One Earth ISH 1 Wednesday 9 July and Thursday 10 July 2025

Summary of Verbal Representations from Newark and Sherwood District Council (NSDC)

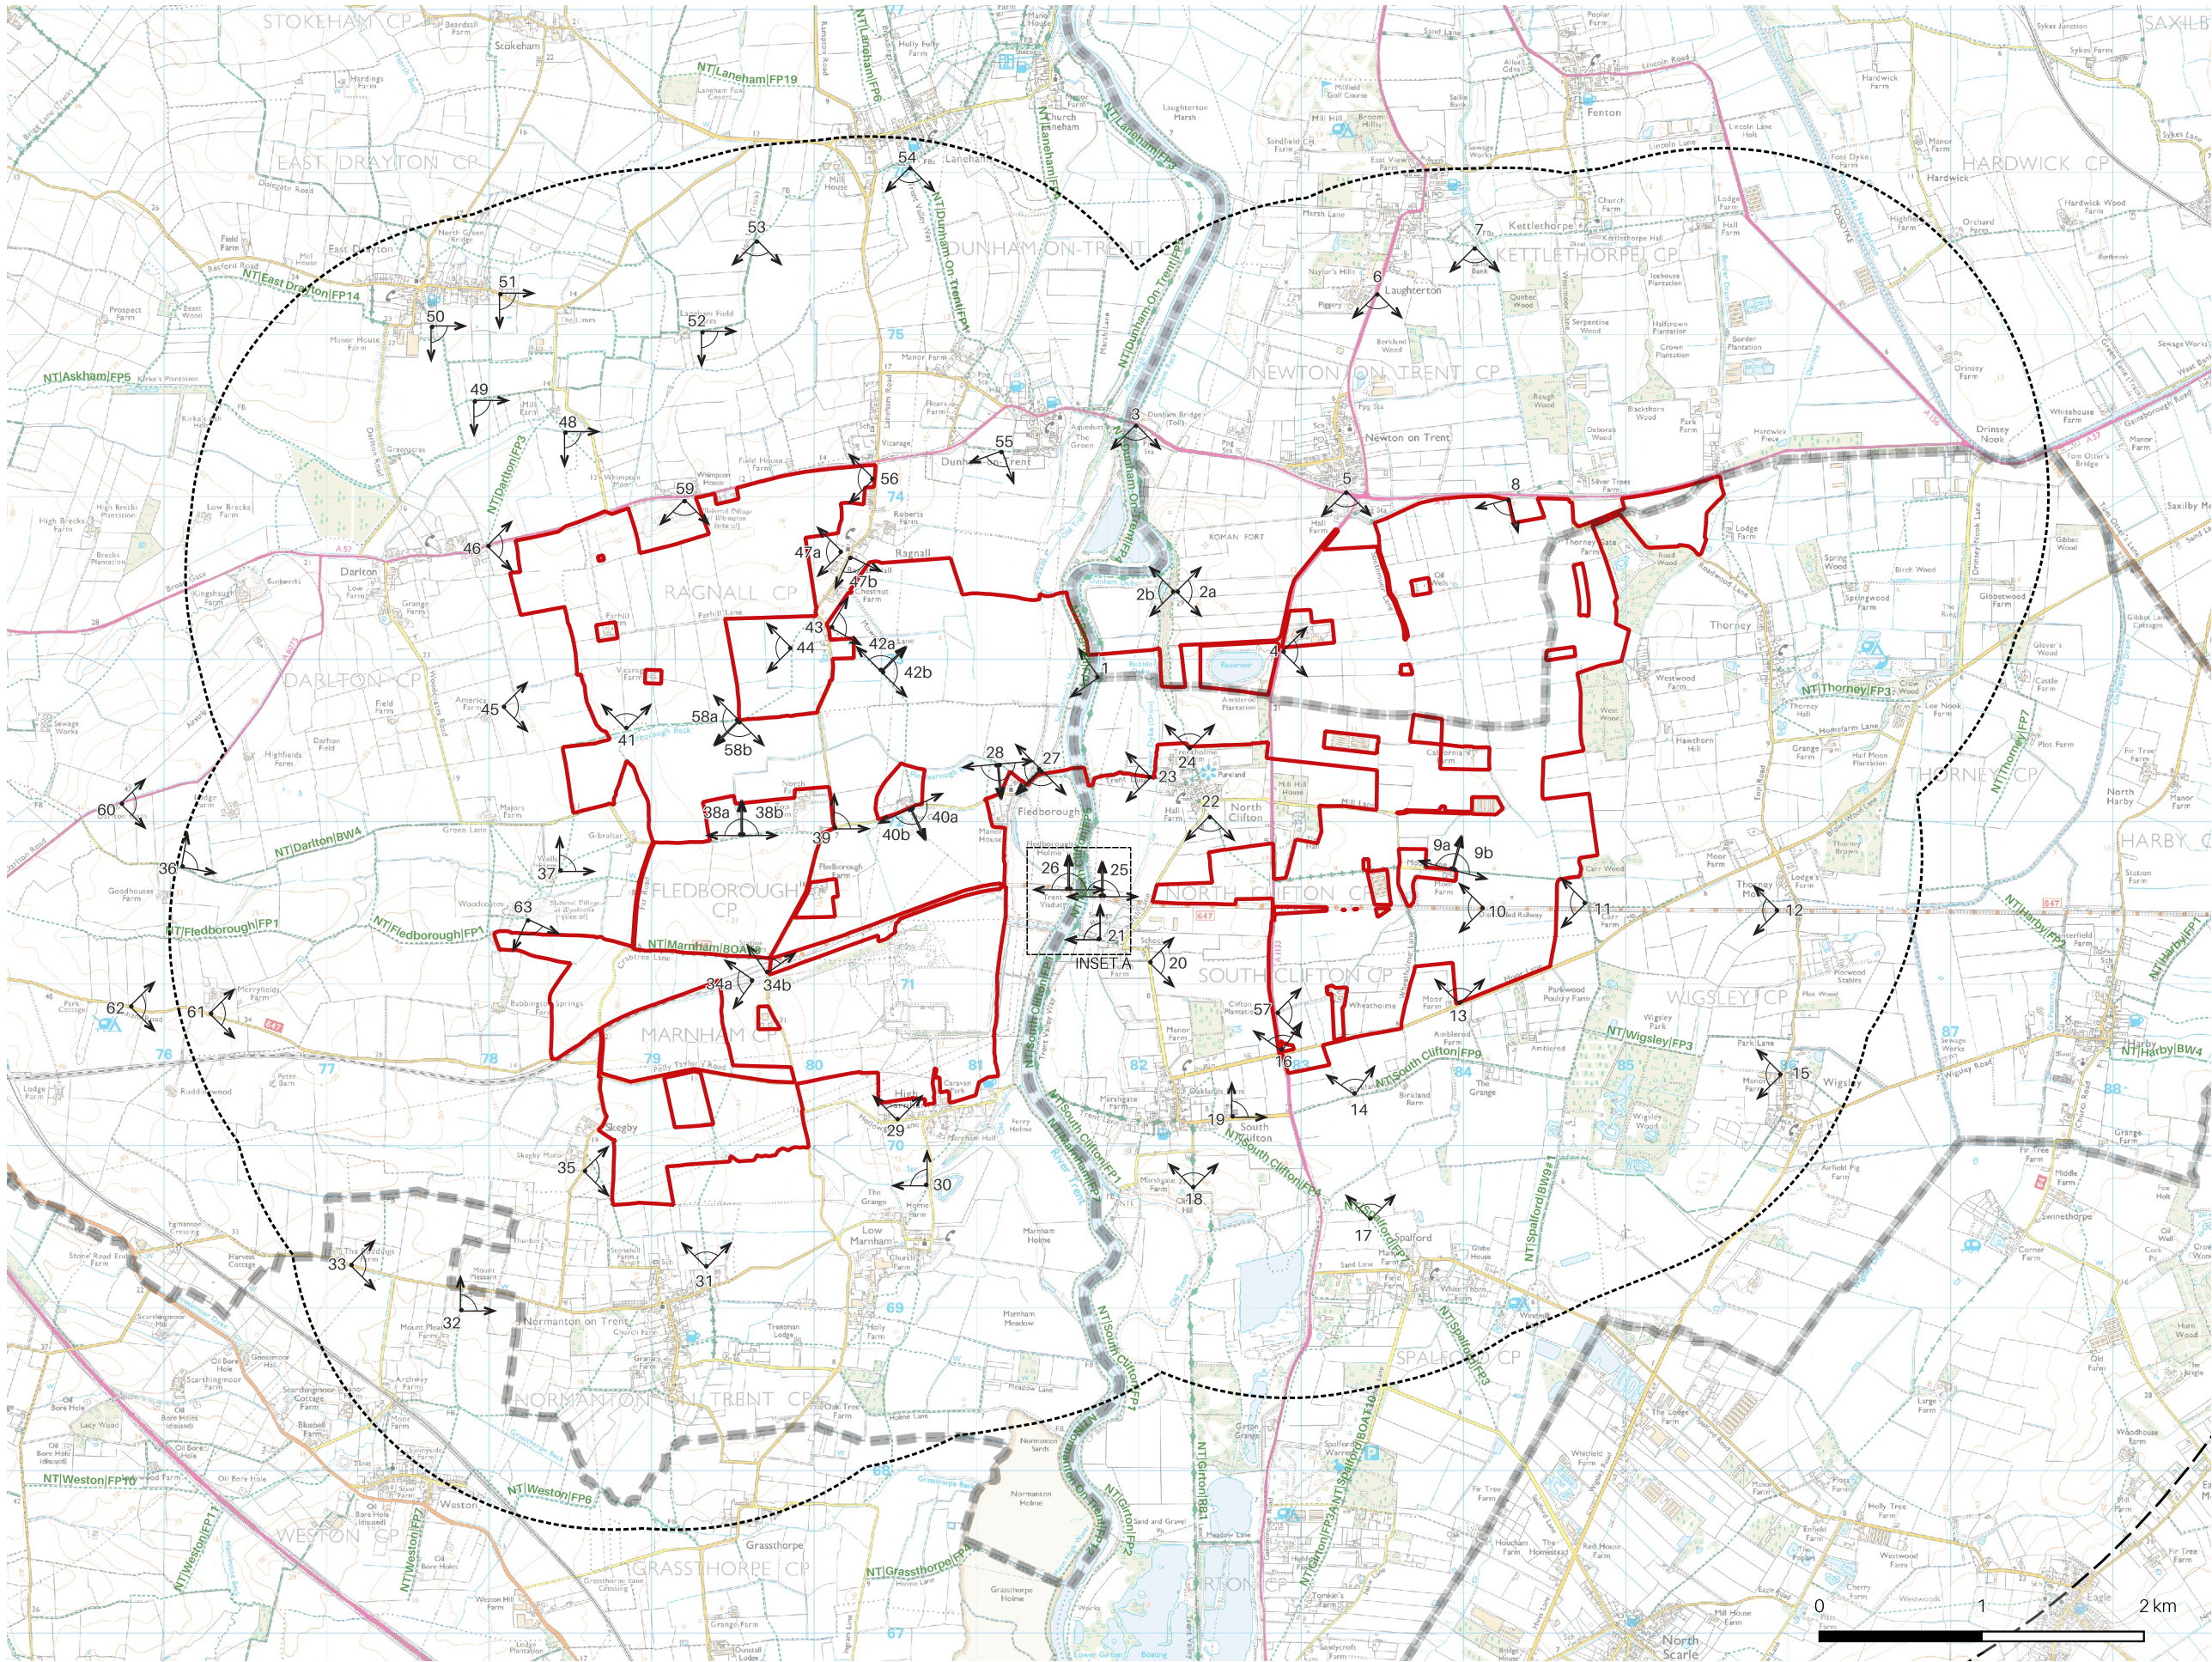
- The visual assessment is structured around static views rather than the experience of the visual receptor which should include for sequential and varying views due to moving through the landscape;

8. Under **Agenda Item 8.3 Landscape (ii)**, while LCC, NCC, NSDC or BDC made no verbal comments on this agenda item due to the pressing agenda timings, we do wish to clarify that while the LVIA identifies PROW users as key receptors, the assessment relies predominantly on static viewpoints, not a full route-based experience. Therefore, understanding the sequential experience of visual receptors is not clear within the LVIA and we would welcome the applicant clarifying how this has been considered. Further detail will be provided within our LIR.
